**From:** Contact Centre (CRM) <contact@ribblevalley.gov.uk>  
**Sent:** 09 December 2023 18:47  
**To:** Planning  
**Subject:** Planning Application Comments - 3/2023/0827 FS-Case-568210582

**Planning Application Reference No.:** 3/2023/0827

**Address of Development:** Rossendale House, York St, Clitheroe

Drawing Title
PROPOSED PLANS

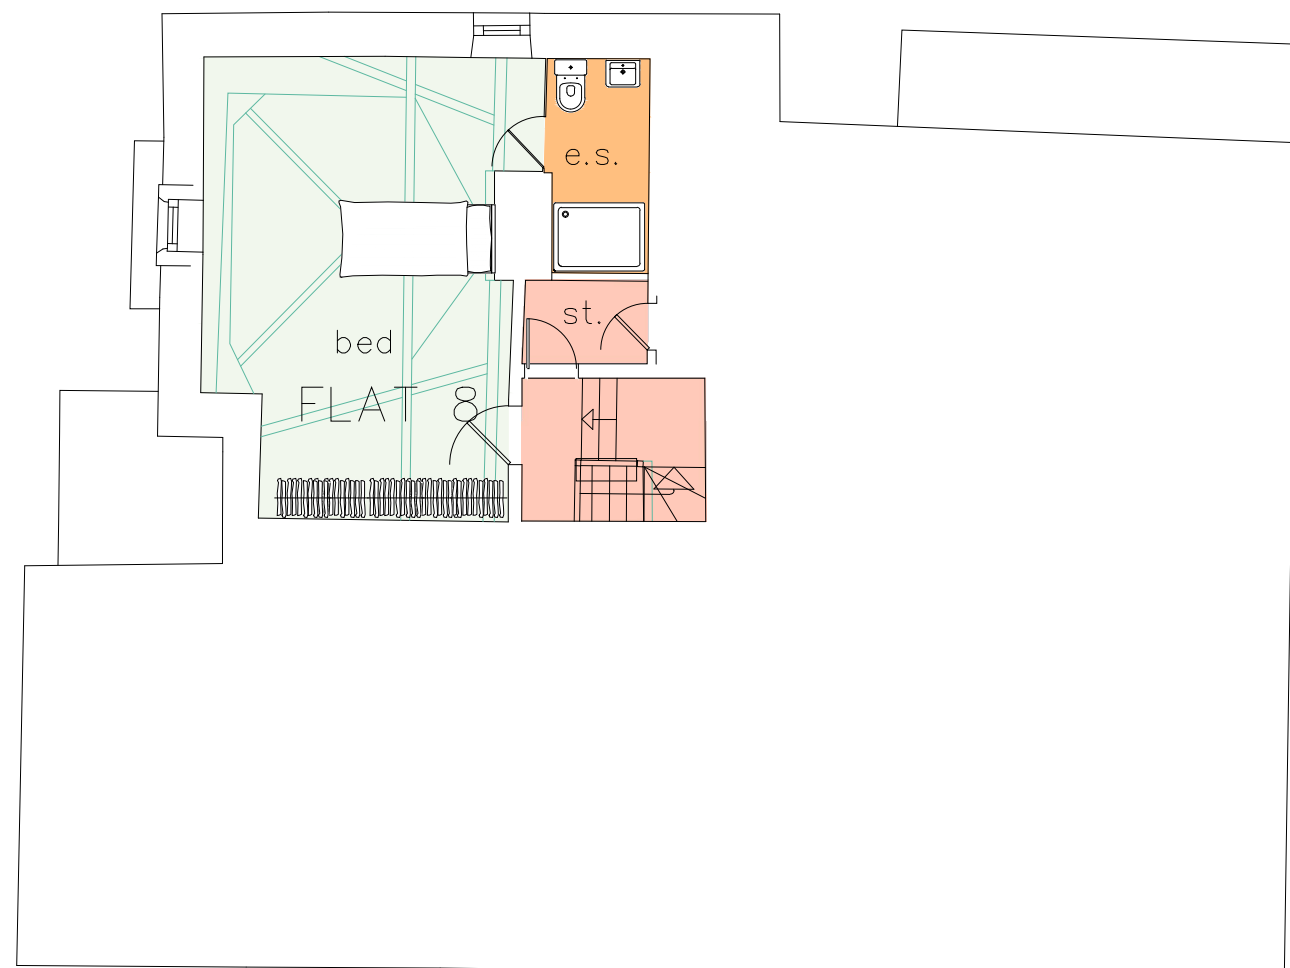
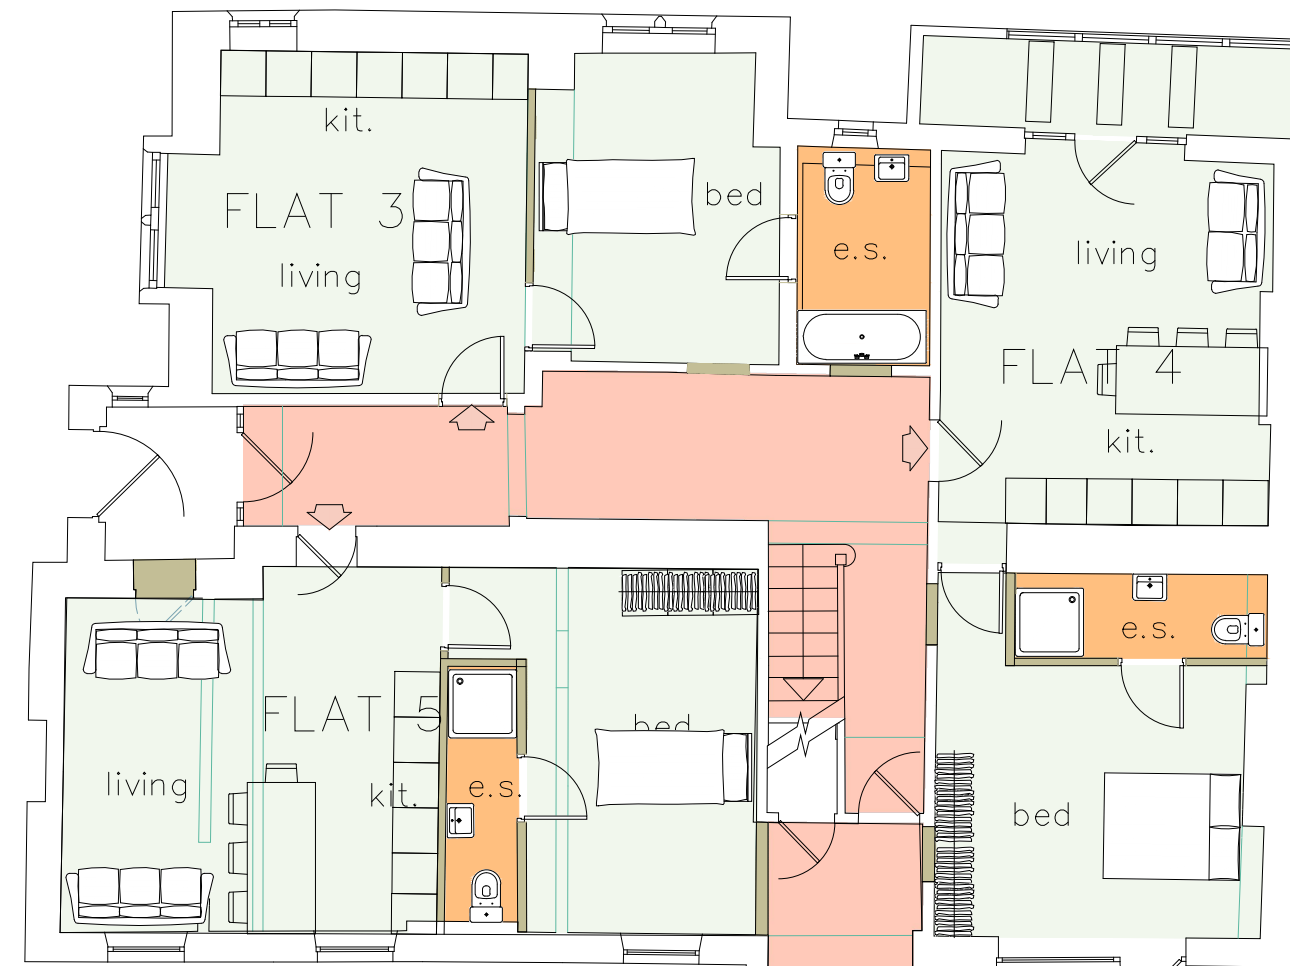
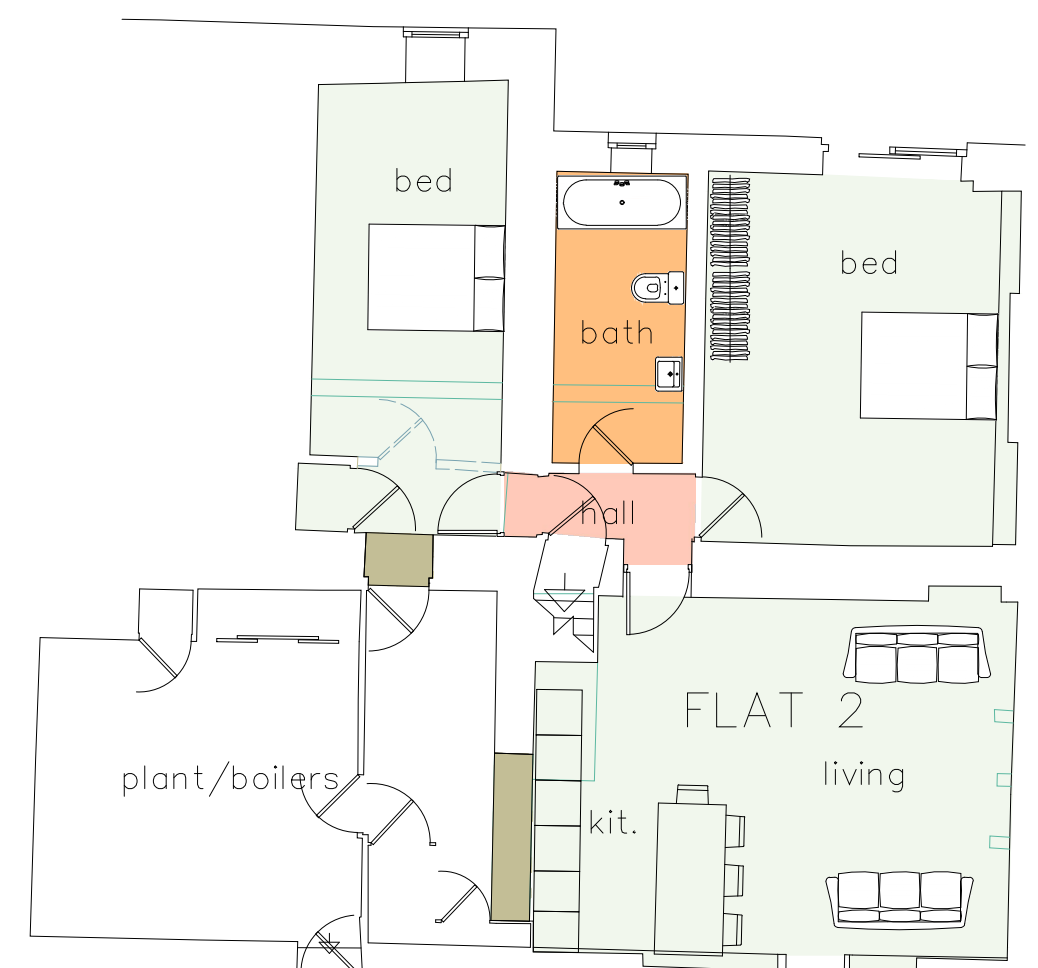
**Comments:** I submit comments on behalf of [REDACTED]  
We find the application somewhat short on detail. Whilst the exterior of the property is stated to stay largely the same as today, questions remain about the statement made. Flats would be accessed from the existing internal staircase and yet access today is only via an external flat roof? Also it references a shop front and I don't believe there is one - or it doesn't make it clear what this actually refers to.  
In addition, for a stated sustainable location (which it is, being on York St) it states there is no requirement for off road parking and yet the location plans show the removal of hedges at the front on York St and provision of car parking spaces in two areas at the front, utilising dropped kerbs? It is this that the [REDACTED] is chiefly concerned about i.e. the impact on the street scene within the designated conservation area. The existing property has hedging at the front and this is a positive addition to the street scene and removal of this for the parking of multiple vehicles would not be welcomed due to the changes to the character of the conservation area if this was to occur.

Safety also is a factor here with any parking being allowed at the front of the property needing to cross the pavement line of this busy location.  
It may be that with added clarity, this application is acceptable, but as it is, it leads to a number of concerns that need to be dealt with before any works are progressed. The [REDACTED] is not against residential development at this location, but our concerns about the impact to the conservation area in this very visible location must be addressed. In a highly sustainable location, provision of multiple parking spaces at the front of a large and visible property in the conservation area is not desirable nor perhaps necessary.
